Recommendation Report for Planning Permission for Works or Extension to a Dwelling

REF NO: FP/125/25/HH

LOCATION: 14 First Avenue
Felpham
PO22 7LG

PROPOSAL: Single storey rear extension. First floor side extension above existing ground floor.

DRAWING TITLE
PROPOSED PLANS

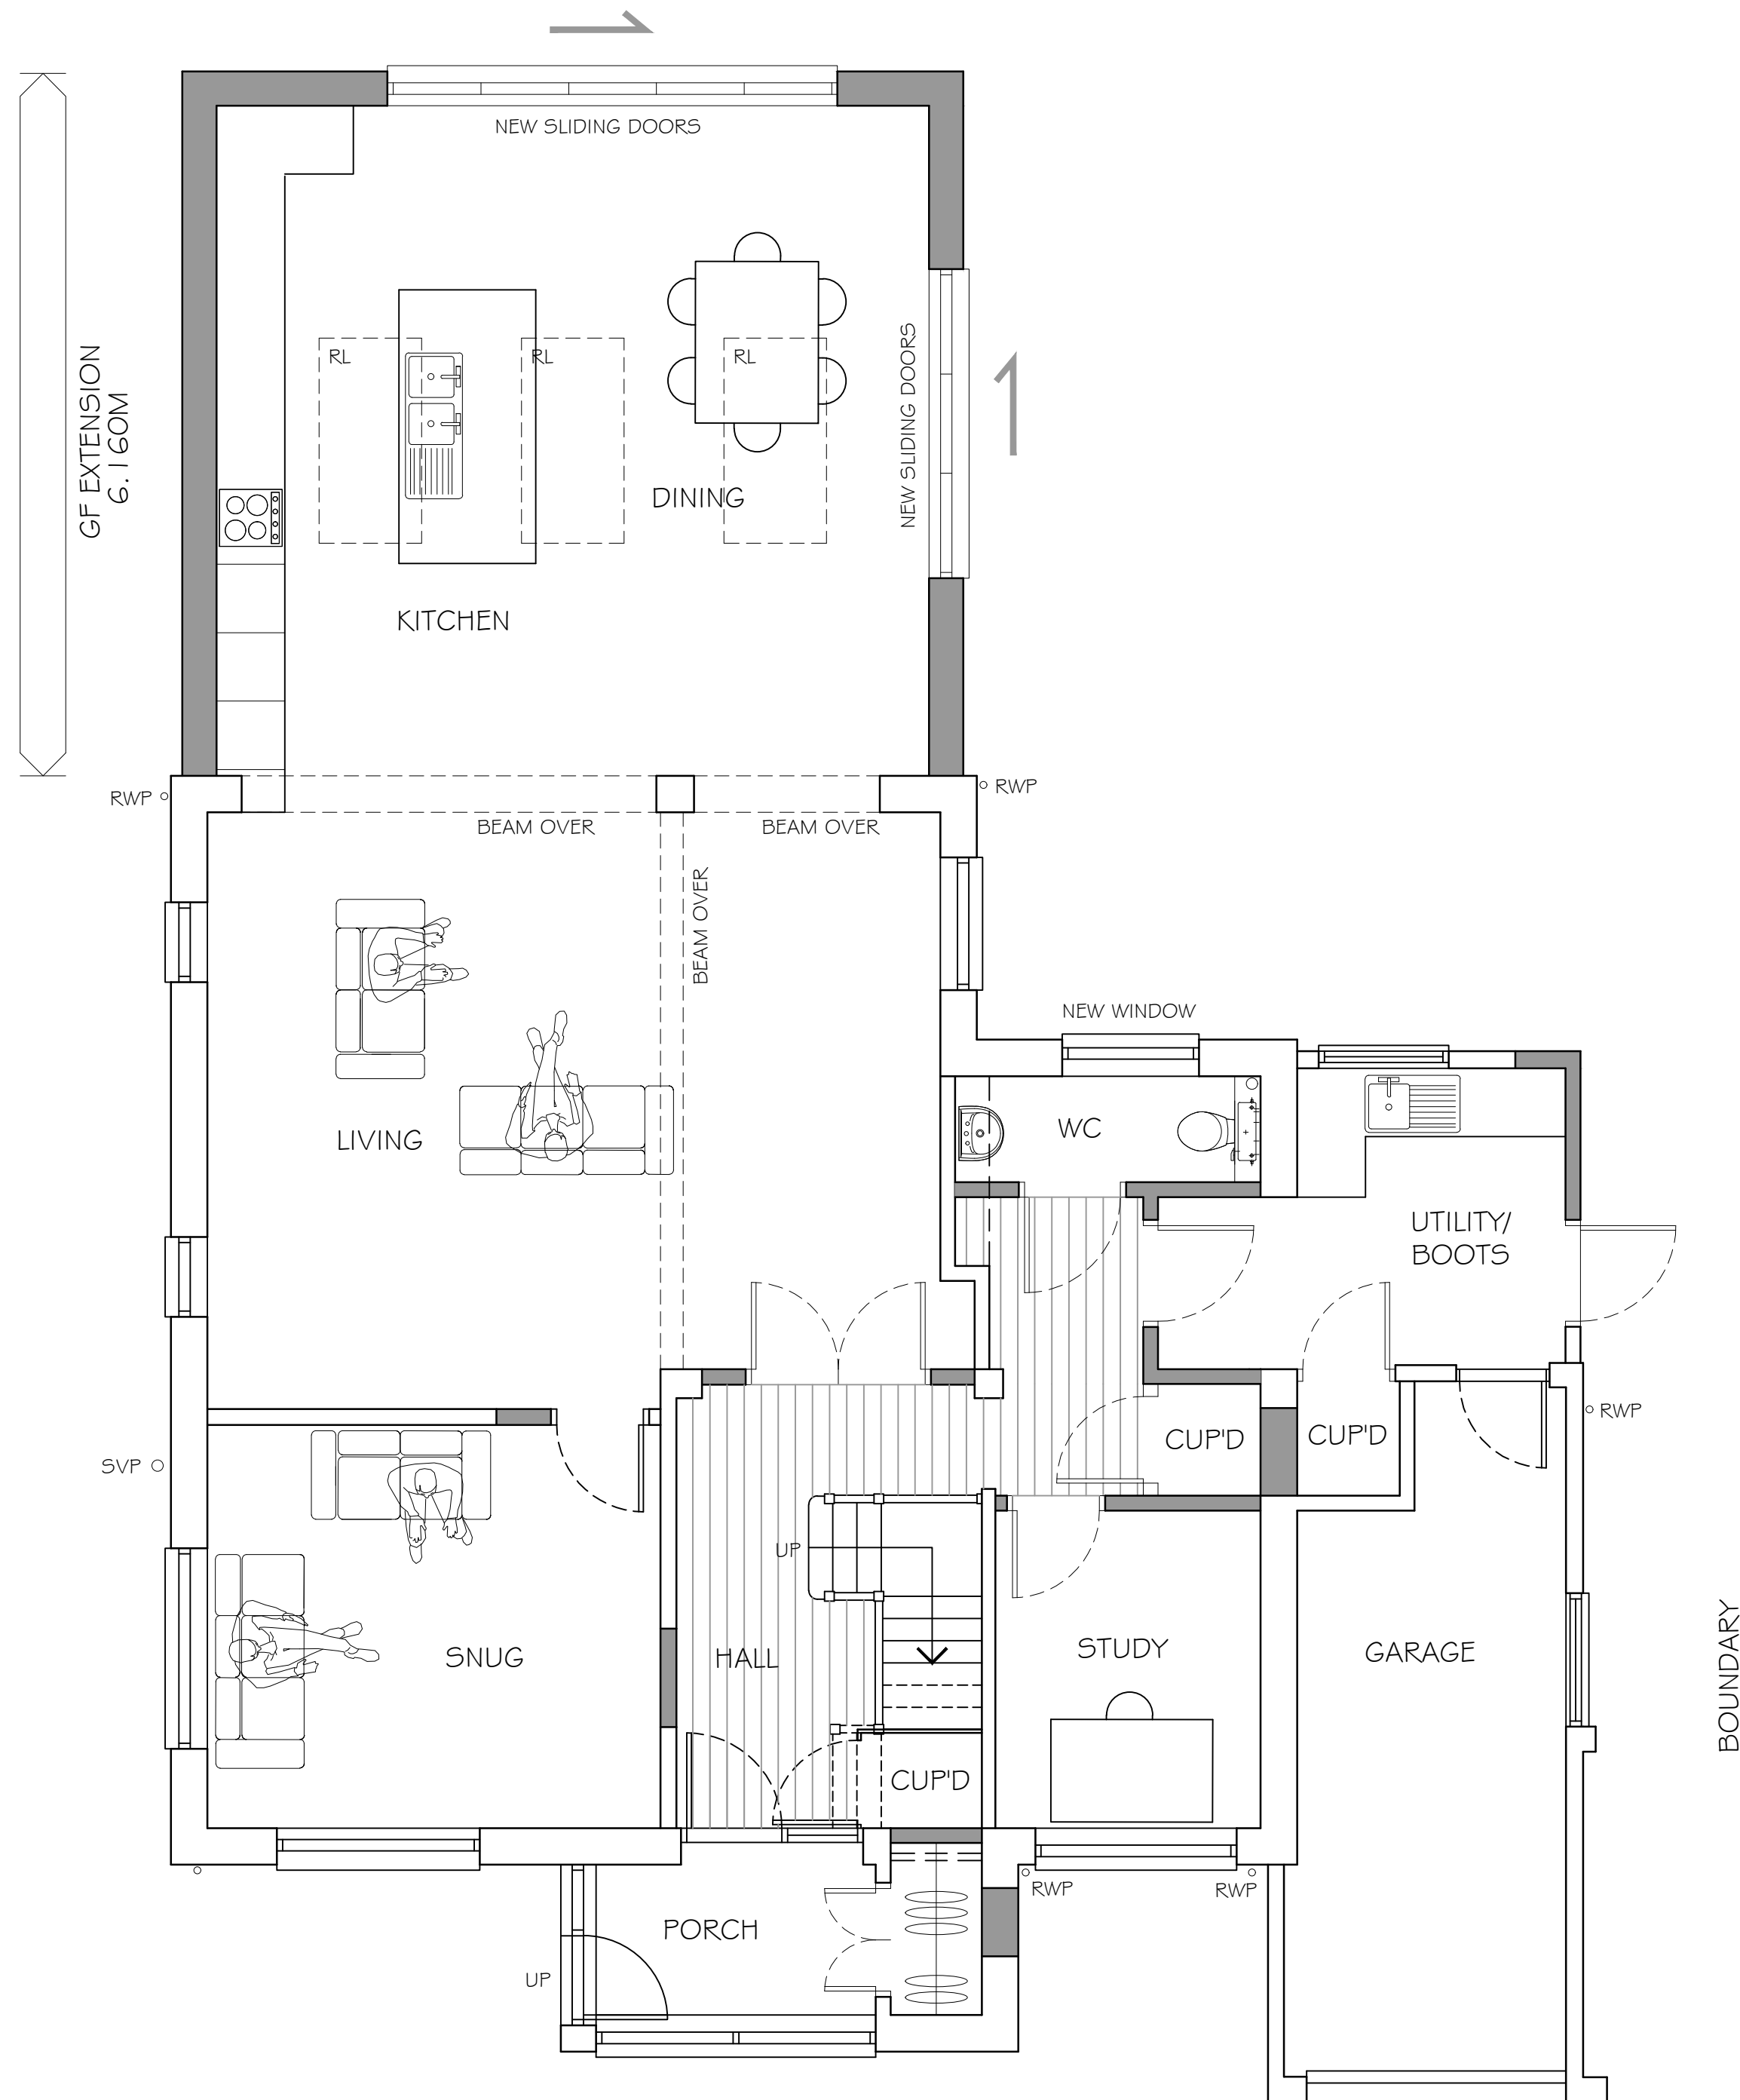
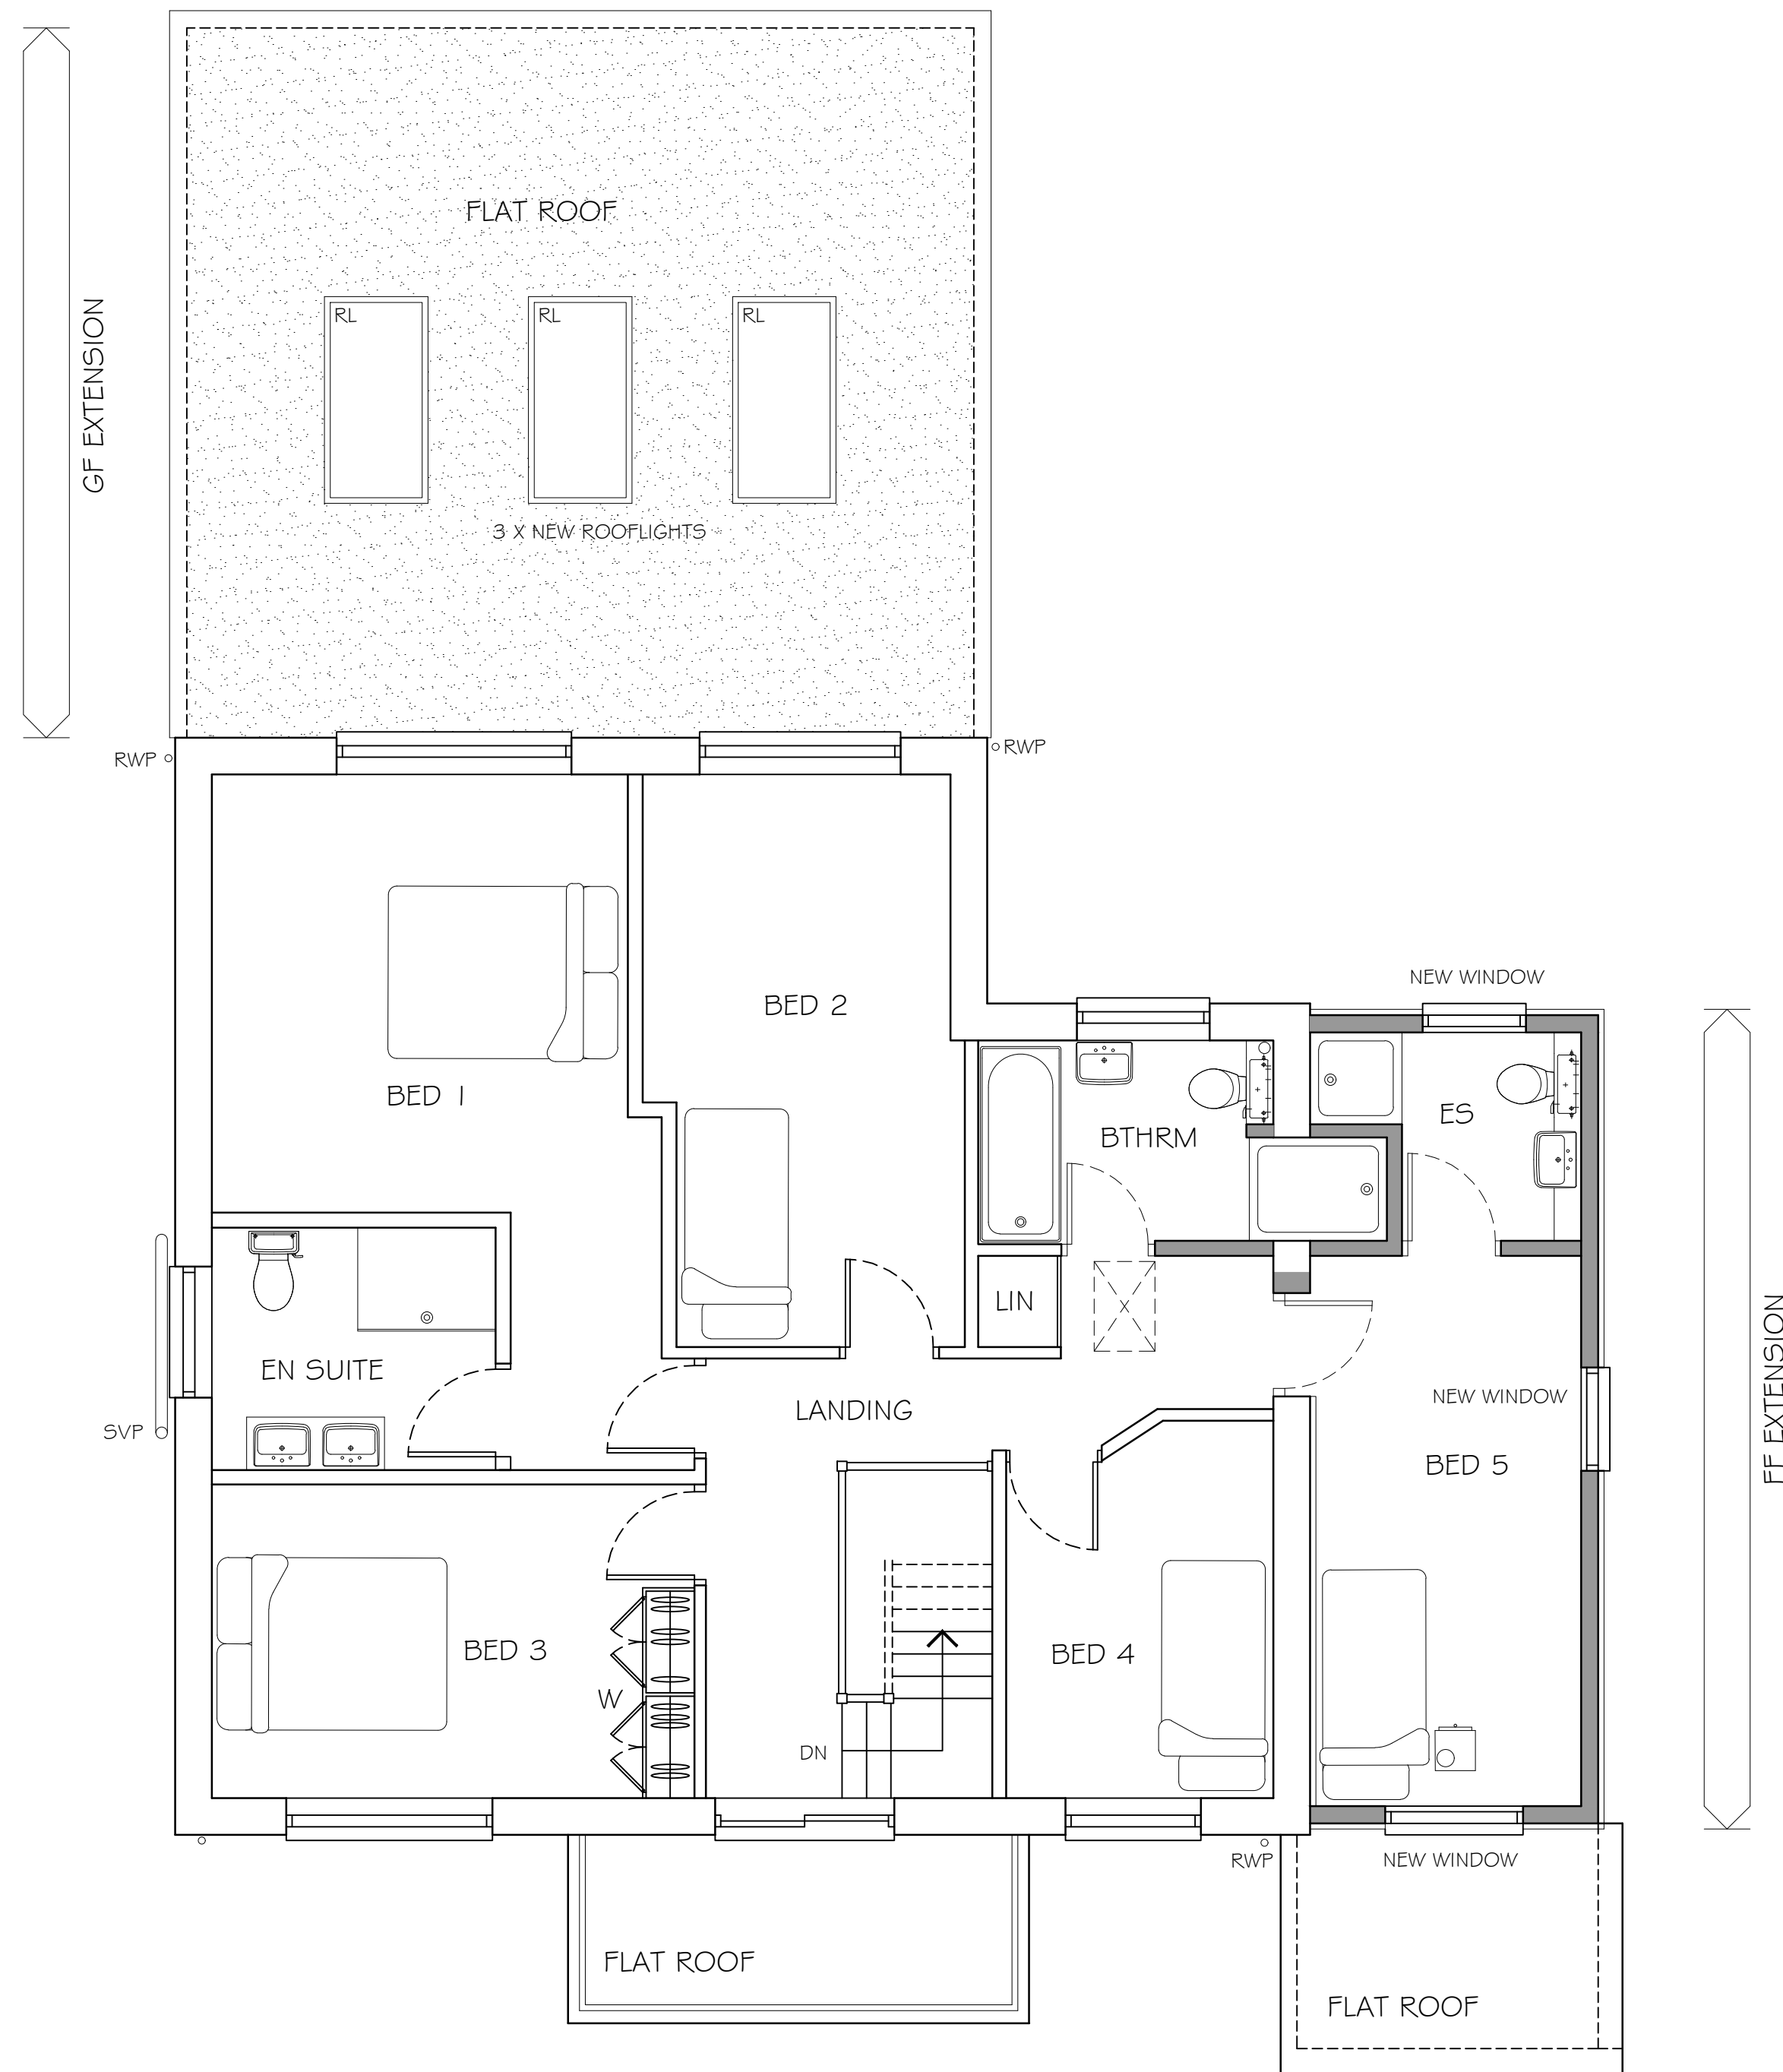
- no scale bars: it is not clear if a 1m gap from the boundary has been maintained on the first floor.
- bedroom 5 - there may be issues with overlooking and it is unclear whether this is diffused glass.
- the proposal fails to comply with Arun District Council Parking Requirements.

The first-floor side extension would be approximately 1.36m from the side boundary (north). This would not comply with the minimum guidance of 2m for a first-floor extension outlined in the ADG policy M. Given the similar side boundary separation with the neighbouring property (north), the spacing maintained between the proposed first-floor side extension and the neighbouring property would not result in harm to the overshadowing or overbearing impacts.

- the scale bar is on the top right hand side of the plans and the gap between the first floor side extension and boundary is approximately 1.3m.
- the neighbouring dormer extension is obscured glass and a condition has been attached to bedroom 5 window (north).
- comments regarding Arun District Council parking requirements have been noted.
